21 December 2010

Re: Major Project MP08_0244 Environmental Assessment (EA) for Construction of a Mixed Use Commercial, Retail and Residential Development at 23-37 Lindfield Avenue and 11 Havilah Avenue, Lindfield

1 JUNE 21 -9AM
1:500

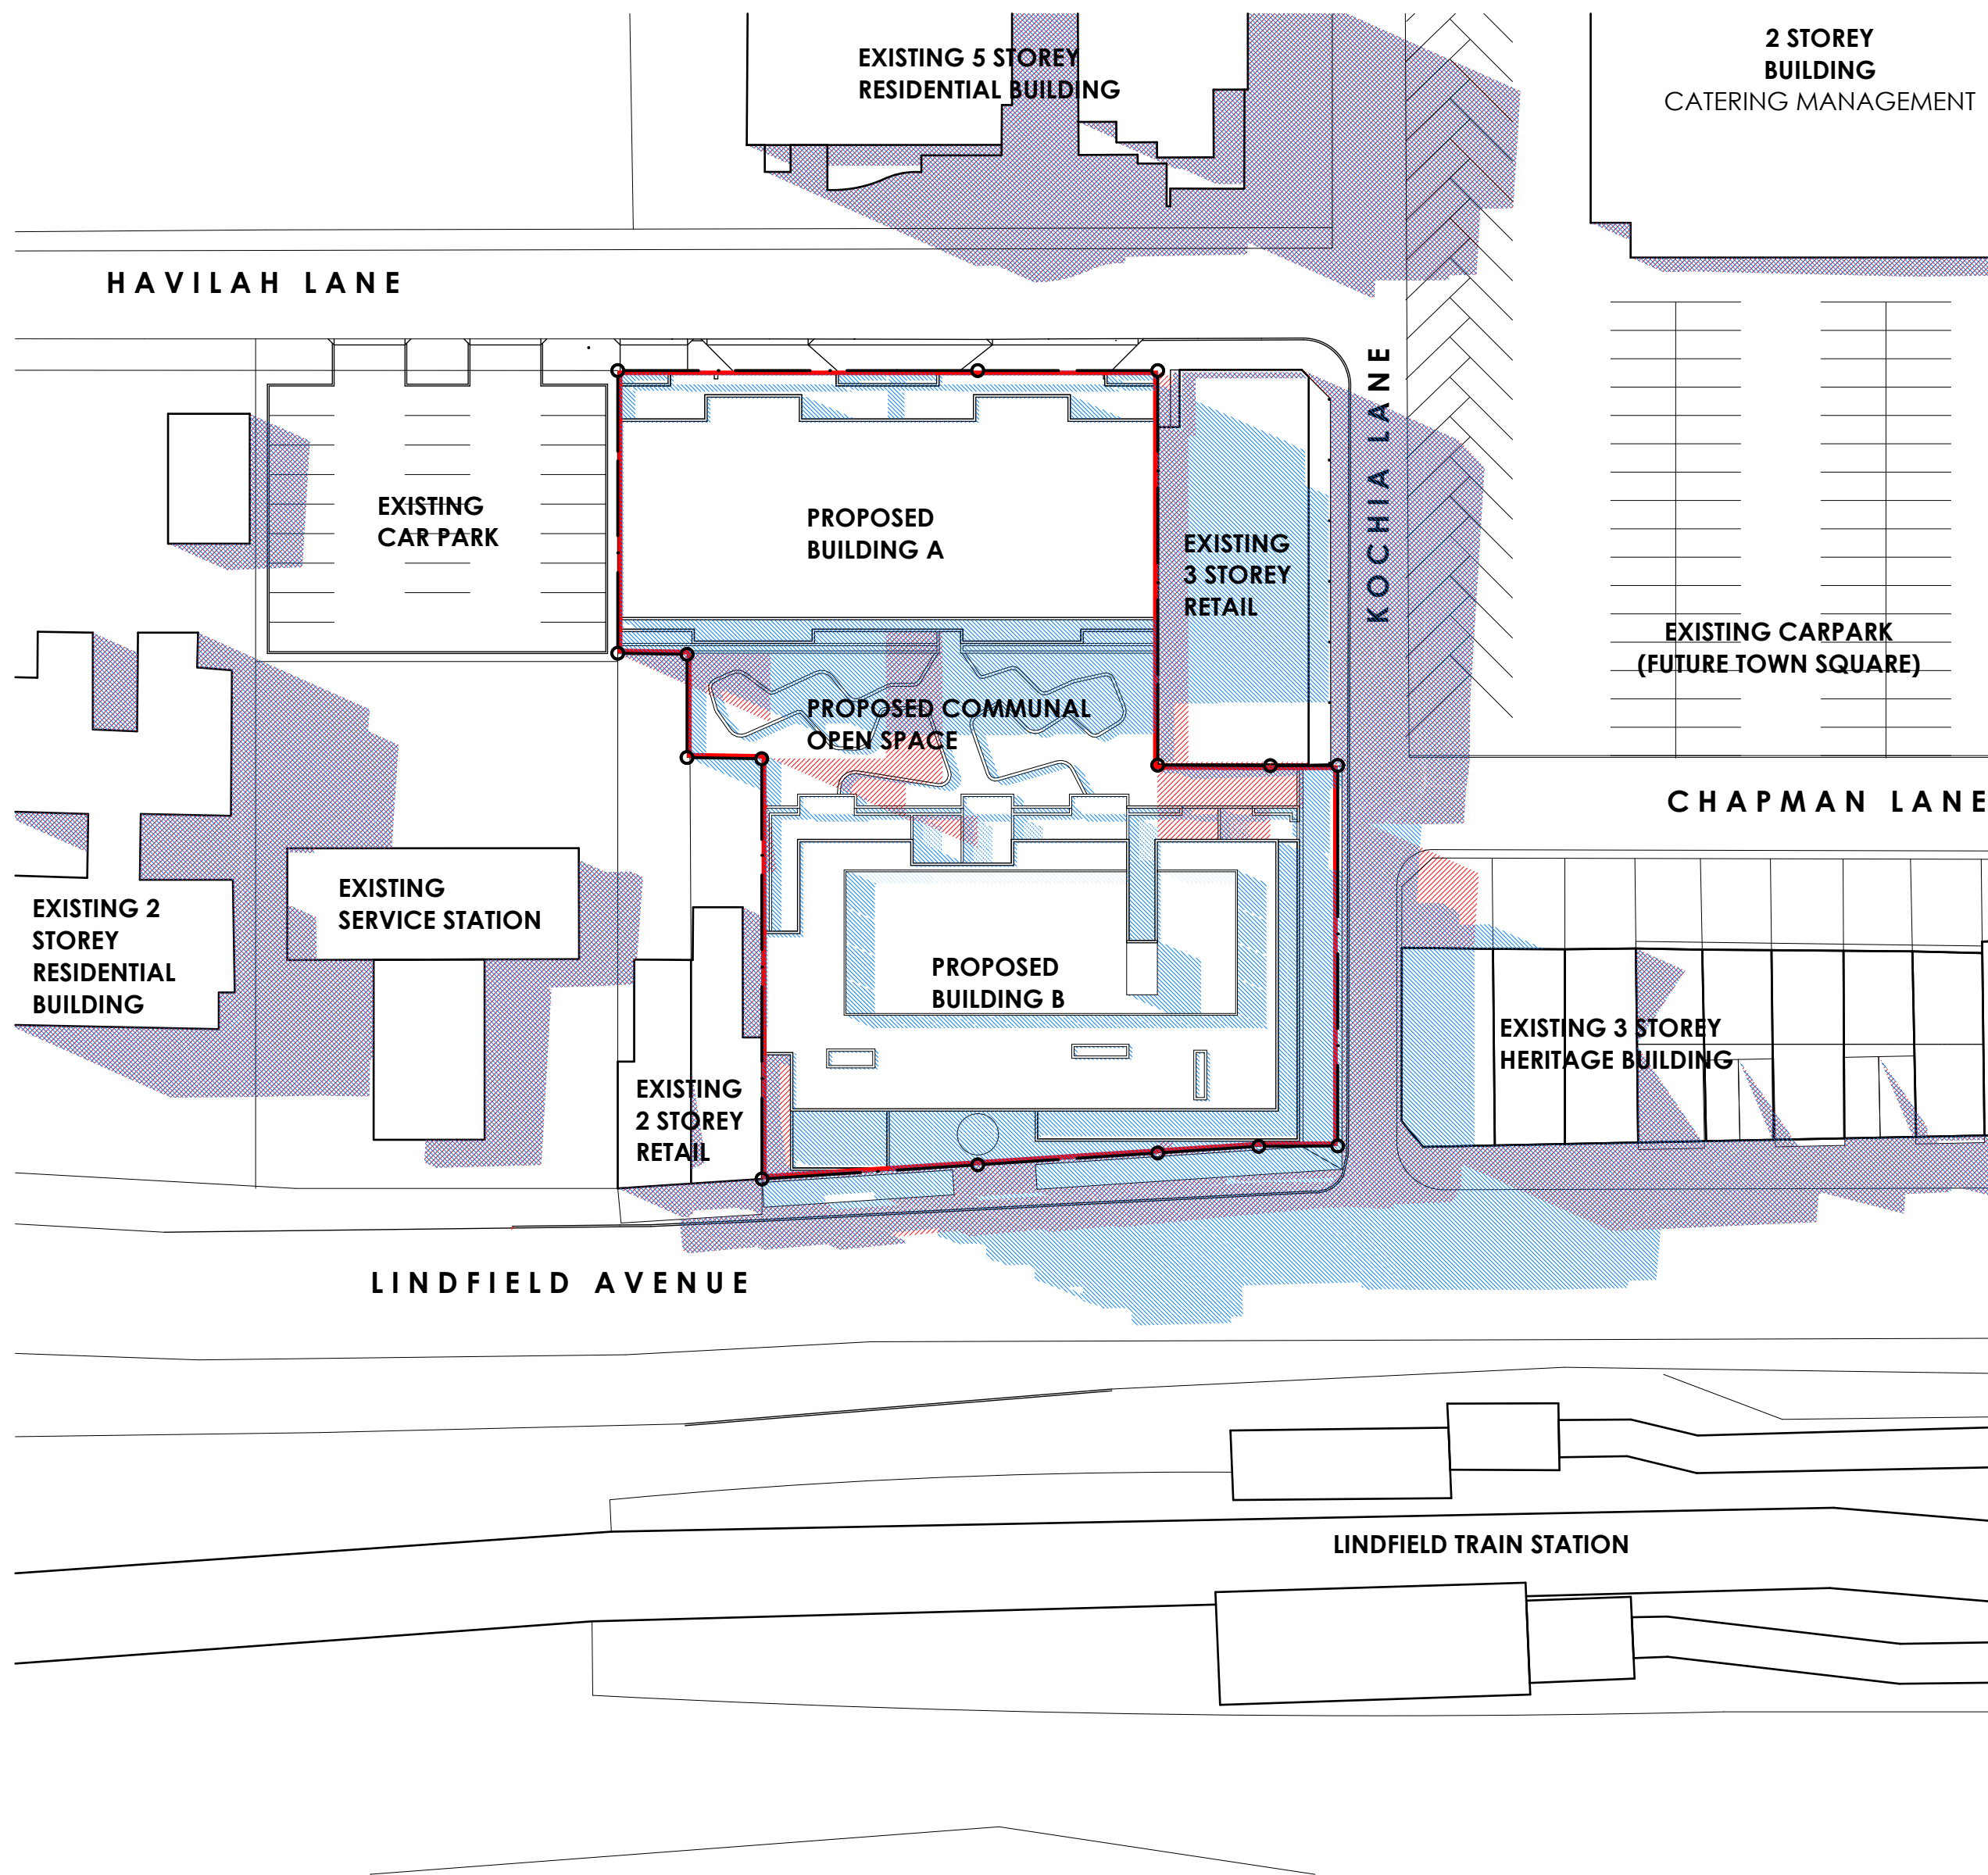
- The Lindfield Avenue building at 7 storeys will cast **significant shadow on the railway station (which is an open station)**, affecting a larger number of commuters as per the March, June and September Shadow Diagrams.

- **The development will cast significant shadows on future open space in the proposed town centre, causing loss of amenity to the broader community**, as per the June and September Shadow Diagrams.
